**Upper South Creek Advanced Water Recycling Centre (SSI-8609189)
Environmental Impact Statement (EIS)**

Liz Rogers
Manager, Assessments, Knowledge Division
Department of Planning, Industry and Environment: Water
30 November 2021

Detailed advice to DPIE Planning & Assessment regarding the Upper South Creek Advanced Water Recycling Centre (SSI-8609189) EIS

Figure 4-20 Pipeline construction corridor widths and layouts

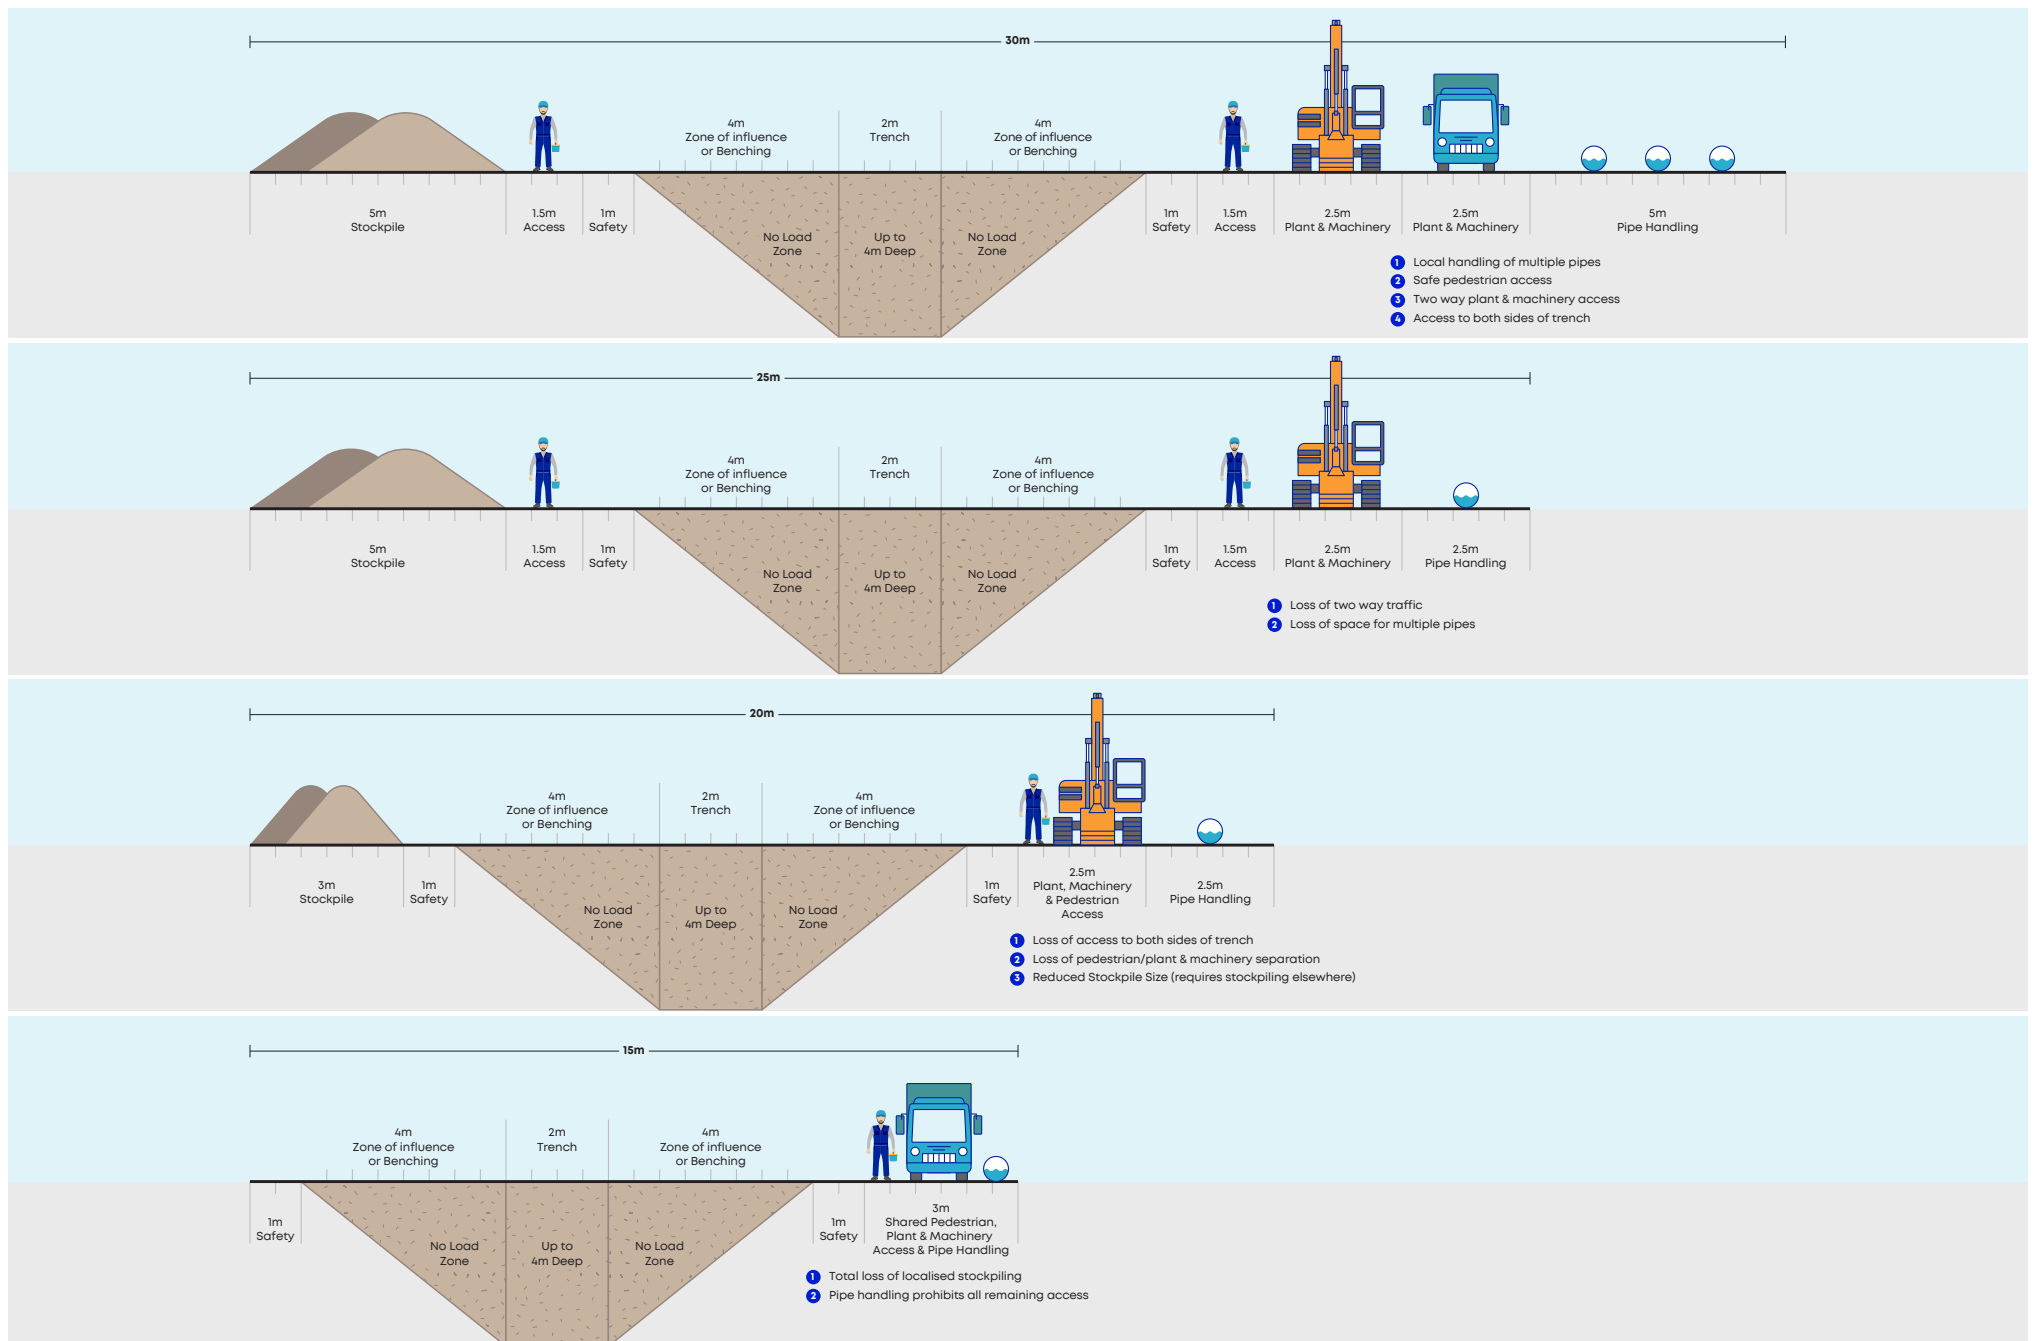
According to page 28 of the executive summary, pipelines will be installed underground using trenching and tunnelling. Trenching would require a corridor width of 15-20m for installation. Tunnelling is mentioned to be used under higher order water courses (as listed below) and roadways. The proponent has not mentioned how far the tunnelling launch site would be from these major watercourses. Trenching in watercourses will involve the installation of coffer dams to stop waterflow and a pump to continue flows from one site of the watercourse to the other while works are being done. Flows are returned to normal after the installation of the pipeline.

- confirm that the launch site for tunnelling the pipeline under watercourses is outside of the riparian area and setback in accordance with the NRAR Guidelines for Controlled Activities which can be found here <https://www.dpie.nsw.gov.au/nrar/how-to-apply/controlled-activities/guidelines-for-controlled-activities>
- provide details of rehabilitation measures proposed for the trenched pipeline installed across watercourses and the duration the trench will be present.
